# The Sizewell C Project

## Non-Material Change 1: Schedule of Proposed Changes to the DCO - Tracked Changes

May 2026

**SIZEWELL C**  
**NON-MATERIAL CHANGE APPLICATION 1 (NMC1)**  
**SCHEDULE OF PROPOSED CHANGES TO THE DCO**

DRAWING TITLE:
TWO VILLAGE BYPASS
RIGHTS OF WAY PLANS - SHEET 18 OF 28

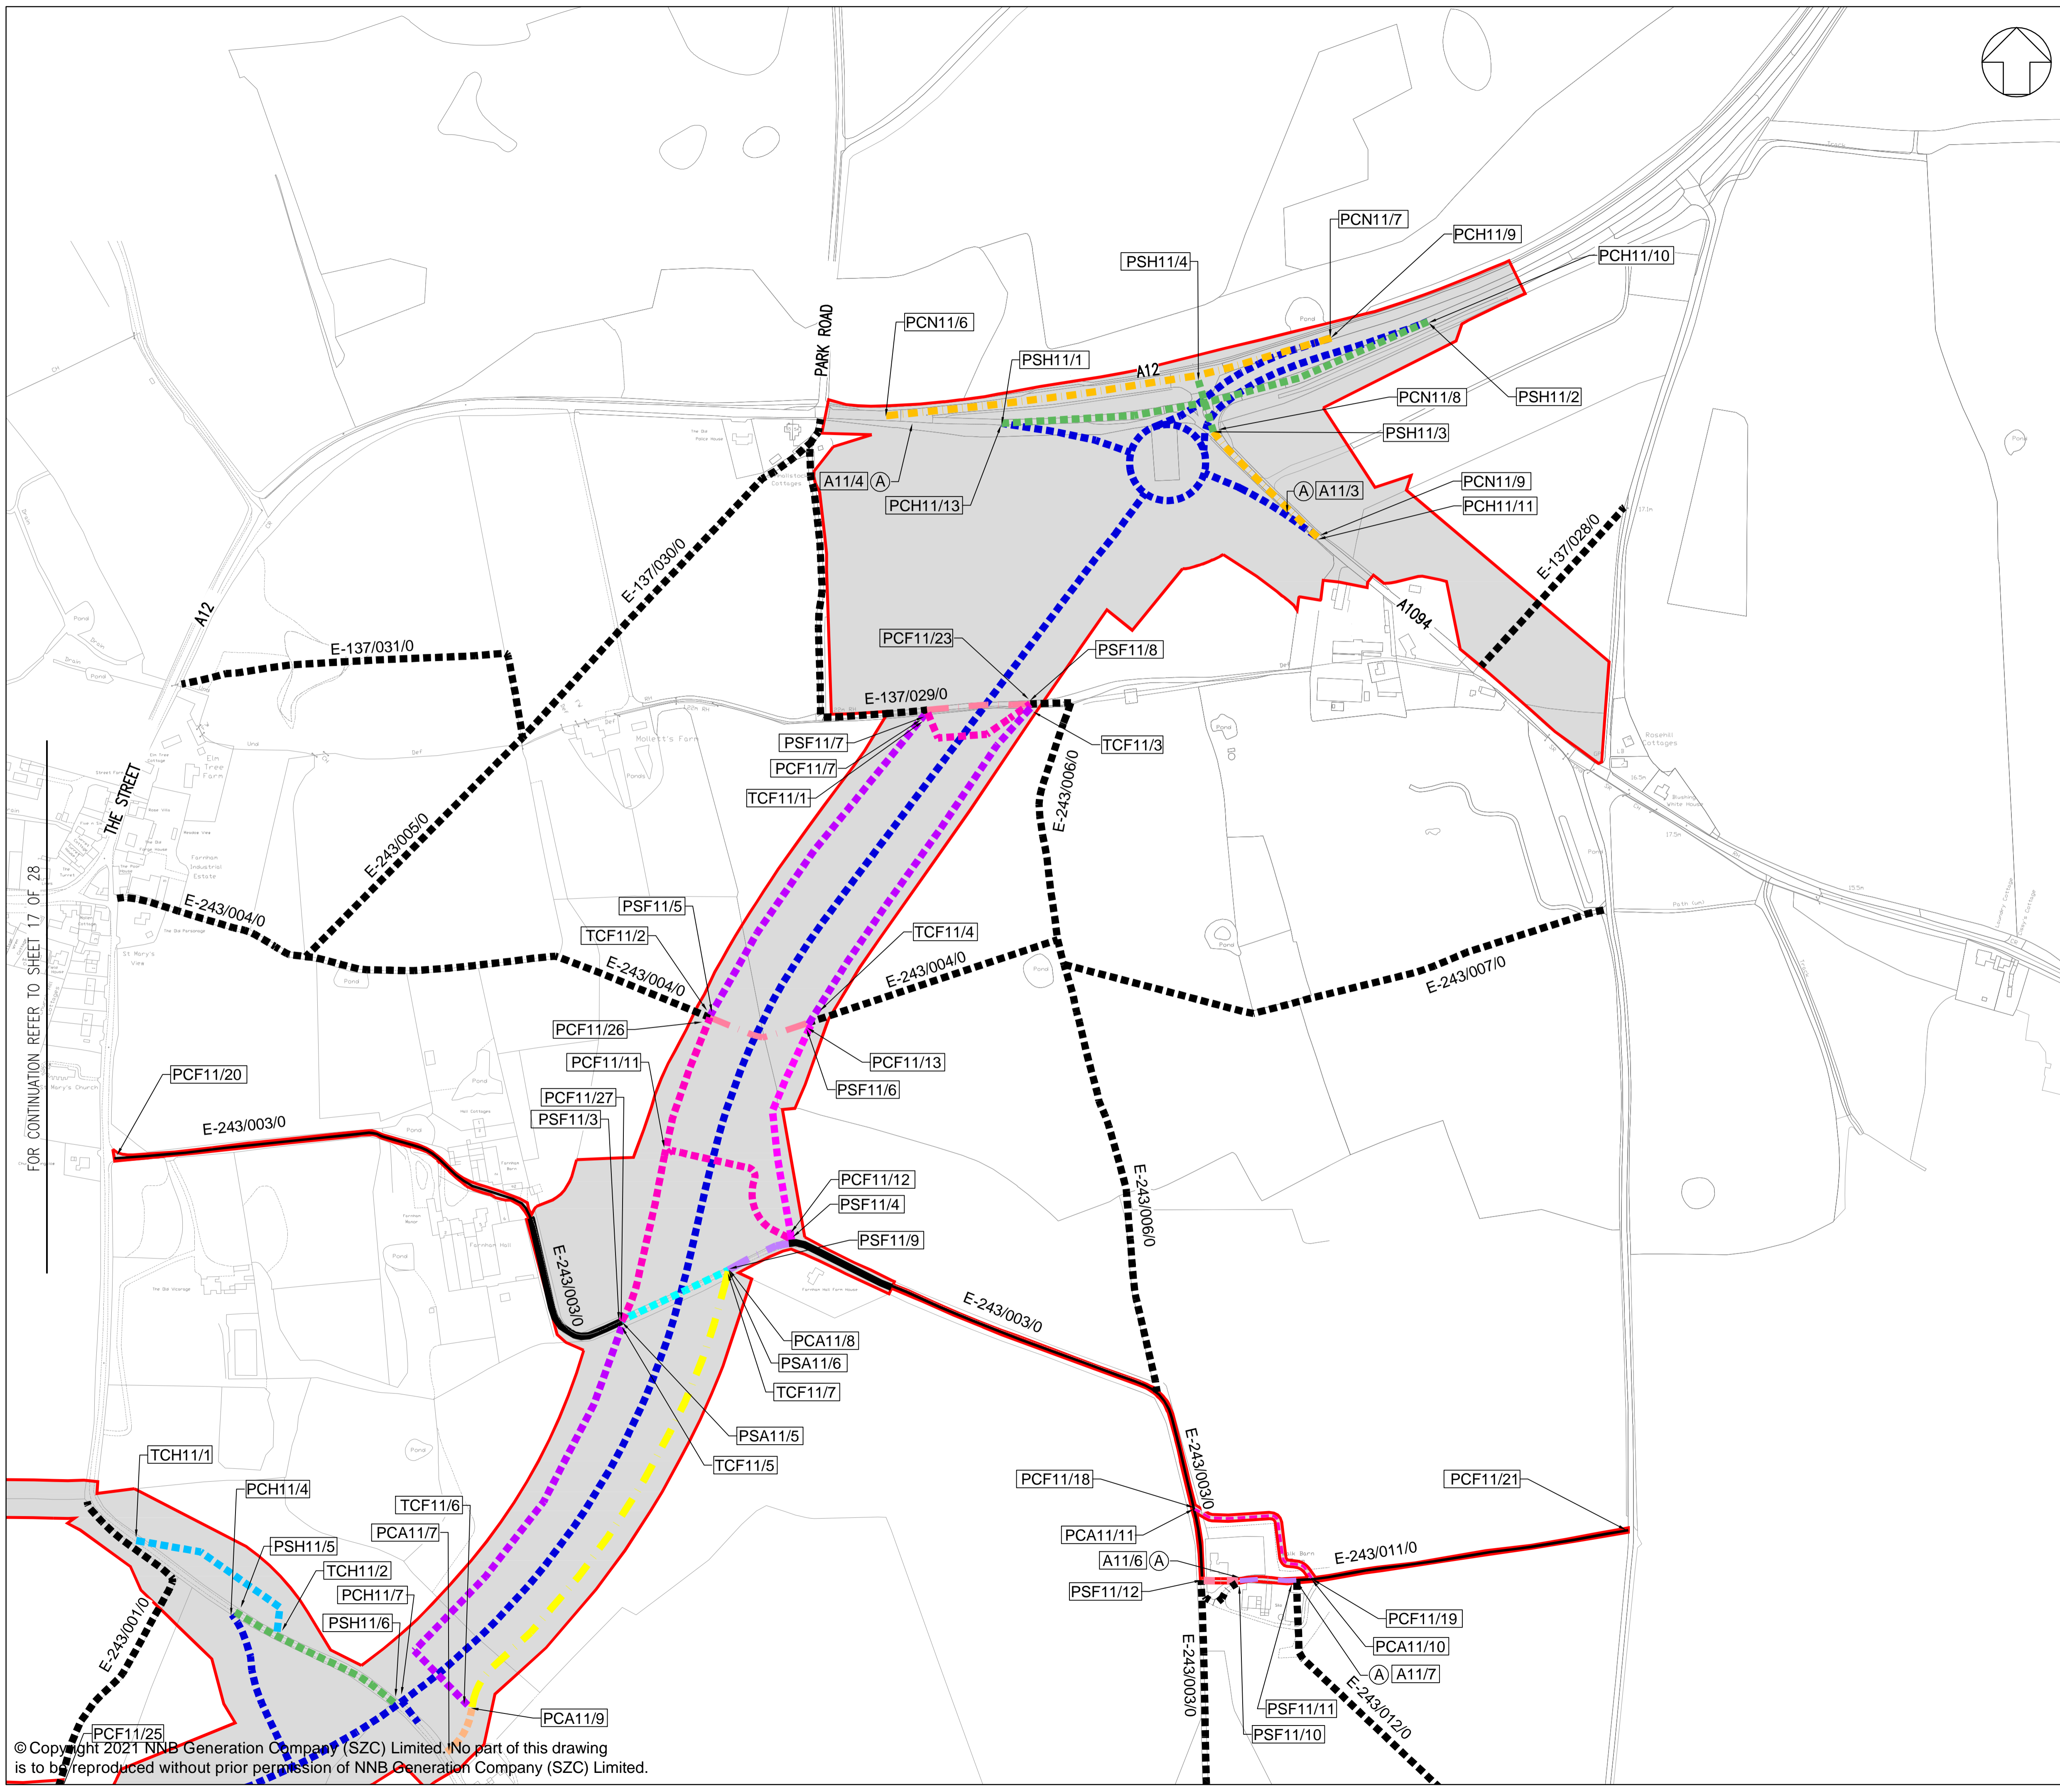
Schedule 10, Part 1	Two village bypass	Farnham Hall farm house	Private means of access between points PSA11/5 and PSA11/6	New private means of access between points PCA11/7, <del>PCA11/19</del> and PCA11/8	Rights of Way Plans – sheet 18 of 28	Change 4 – PRoW	The justification for these changes is set out in the NMC1 Application Report.
	Two village bypass	Highway (footpath) E-243/003/0	Highway (footpath) between point PSF11/3, <del>and PSF11/9 and PSF11/4</del>	New highway (footpath) between points PCF11/27, PCF11/11, PCF11/28 and PCF11/12	Rights of Way Plans – sheet 18 of 29		
Schedule 10, Part 1	Sizewell link road	Highway (footpath) E-344/013/0 <del>and highway (footpath) E-584/016A</del>	Highway (footpath) between points PSF12/3 and PSF12/4	New highway (footpath) between points PCF12/3 and PCF12/4	Rights of Way Plans – sheet 19 of 28	Change 4 – PRoW	The justification for these changes is set out in the NMC1 Application Report.

<p><b>Schedule 12 (Benefit of permanent private means of access and private rights of way created)</b></p>	<table border="1"> <tr> <td data-bbox="604 218 851 383">Land Registry Title SK269598 (Farnham Hall Farmhouse)</td> <td data-bbox="851 218 1025 383">Land Registry Titles SK349176 and SK267263</td> <td data-bbox="1025 218 1227 383">Between points PCA11/7; <del>PCA11/9</del> and PCA11/8</td> <td data-bbox="1227 218 1379 383">Rights of Way Plan – sheet 18 of 28</td> </tr> <tr> <td data-bbox="604 383 851 584">Land Registry SK349176 (Walk Barn Farm)</td> <td data-bbox="851 383 1025 584">Land Registry Title SK267263</td> <td data-bbox="1025 383 1227 584">Between points PCA11/7; <del>PCA11/9</del> and PCA11/8</td> <td data-bbox="1227 383 1379 584">Rights of Way Plan – sheet 18 of 28</td> </tr> </table>	Land Registry Title SK269598 (Farnham Hall Farmhouse)	Land Registry Titles SK349176 and SK267263	Between points PCA11/7; <del>PCA11/9</del> and PCA11/8	Rights of Way Plan – sheet 18 of 28	Land Registry SK349176 (Walk Barn Farm)	Land Registry Title SK267263	Between points PCA11/7; <del>PCA11/9</del> and PCA11/8	Rights of Way Plan – sheet 18 of 28	<p>Change 4 – PRow</p>	<p>The justification for these changes is set out in the NMC1 Application Report.</p>
Land Registry Title SK269598 (Farnham Hall Farmhouse)	Land Registry Titles SK349176 and SK267263	Between points PCA11/7; <del>PCA11/9</del> and PCA11/8	Rights of Way Plan – sheet 18 of 28								
Land Registry SK349176 (Walk Barn Farm)	Land Registry Title SK267263	Between points PCA11/7; <del>PCA11/9</del> and PCA11/8	Rights of Way Plan – sheet 18 of 28								
<p><b>Schedule 16 (Modification of compensation and compulsory purchase enactments for creation of new rights and imposition of restrictive covenants), paragraph 4(2)</b></p>	<p>(2) Without limiting the scope of sub-paragraph (1), Part 1 of the 1965 Act applies in relation to the compulsory acquisition under this Order of a right by the creation of a new right or; in relation to the imposition of a restriction; with the modifications specified in the following provisions of this Schedule.</p>	<p>Change 8 – Corrections</p>	<p>Typographical correction.</p>								
<p><b>Schedule 19 (Protective Provisions), Part 8 (For the protection of the Nuclear Decommissioning Authority and Magnox), paragraph 89</b></p>	<p>89. If, in the exercise of the powers conferred by this Order, the undertaker acquires any interest in any land in which any installation is located or placed, that installation must not be removed under this Part or under any other statutory power, and any right of NDA and / or Magnox (as applicable) to use, access, maintain, or renew installations on, in or over that land must not be extinguished until either alternative installations have been constructed in accordance with paragraph <del>105</del> 90 of this Part and are in</p>	<p>Change 8 – Corrections</p>	<p>Paragraph cross-reference corrected from '105' to '90' to resolve a drafting error.</p>

DRAWING TITLE:
 SIZEWELL LINK ROAD
 RIGHTS OF WAY PLANS - SHEET 21 OF 28

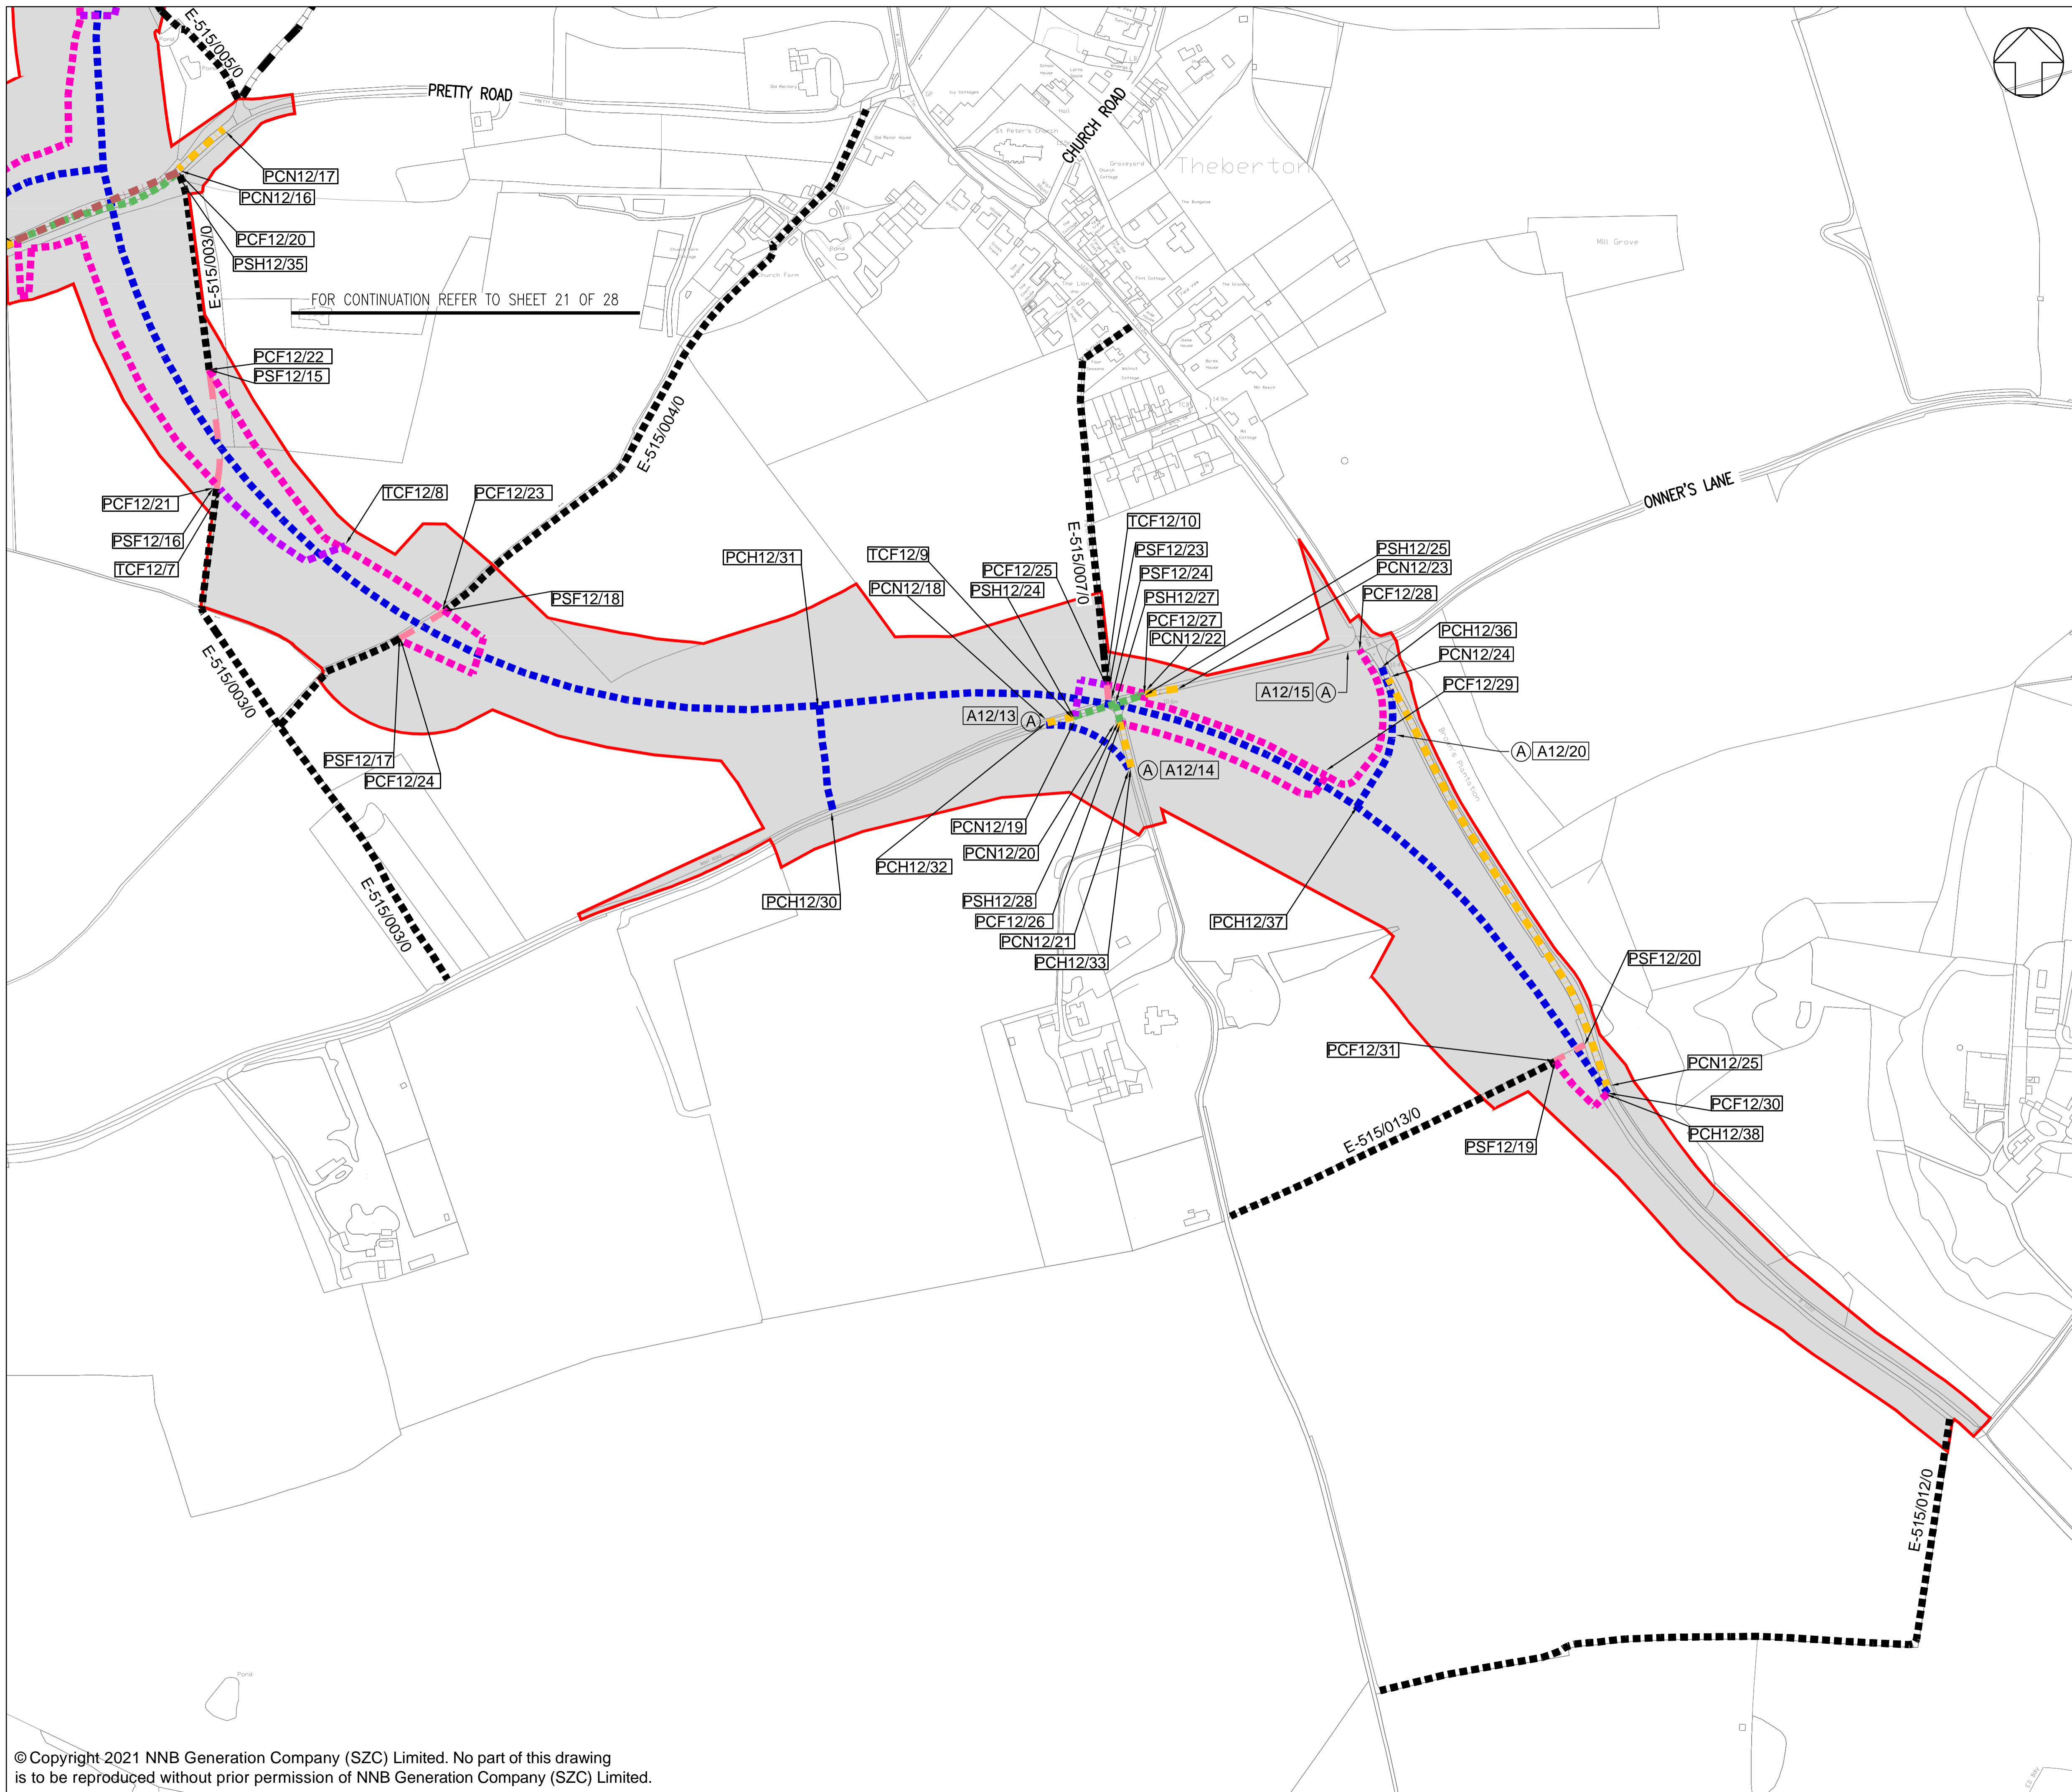
Schedule 10, Part 1	Sizewell link road	Unnamed road	Private means of access between points PSA12/1, <del>PSA12/6,</del> <del>PSA12/3,</del> and PSA12/5	New private means of access between points PCA12/3 and PCA12/4 New Highway (all traffic) between points PCH12/41, PCH12/17, PCH12/16	Rights of Way Plans – sheet 21 of 28	Change 4 – PRoW	The justification for these changes is set out in the NMC1 Application Report.
	Sizewell link road	Highway (footpath) E-396/023/0	Highway (footpath) between points PSF12/ <del>21</del> 29 and PSF12/22	New highway (footpath) between points PCF12/ <del>14</del> 13 and PCF12/15	Rights of Way Plans – sheet 21 of 28		
	<del>Sizewell link road</del>	<del>Highway (footpath) E-396/023/0</del>	<del>Highway (footpath) between points PSF12/29 and PSF12/30</del>	<del>New highway (footpath) between points PCF12/13 and PCF12/47</del>	<del>Rights of Way Plans – sheet 21 of 28</del>

<b>Schedule 11 (Status of public rights of way created or improved)</b>	Sizewell link road	New highway (footpath) between PCF12/13 <del>4</del> and PCF12/15	Footpath	Rights of Way Plan – sheet 21 of 28	Change 4 – PRoW	The justification for these changes is set out in the NMC1 Application Report.
	Sizewell link road	New highway (footpath) between PCF12/13 and PCF12/47	Footpath	Rights of Way Plan – sheet 21 of 28		
<b>Schedule 11 (Status of public rights of way created or improved)</b>	Sizewell link road	New highway (footpath) between points PCF12/38, <del>and PCF12/39</del> <del>and PCF12/41</del>	Footpath and cycle track	Rights of Way Plan – sheet 22 of 28	Change 4 – PRoW	The justification for these changes is set out in the NMC1 Application Report.
<b>Schedule 11 (Status of public rights of way created or improved)</b>	Sizewell link road	New highway (footpath) between points PCF12/50 and PCF12/73	Footpath	Rights of Way Plan – sheet 20 of 28	Change 4 – PRoW	The justification for these changes is set out in the NMC1 Application Report.
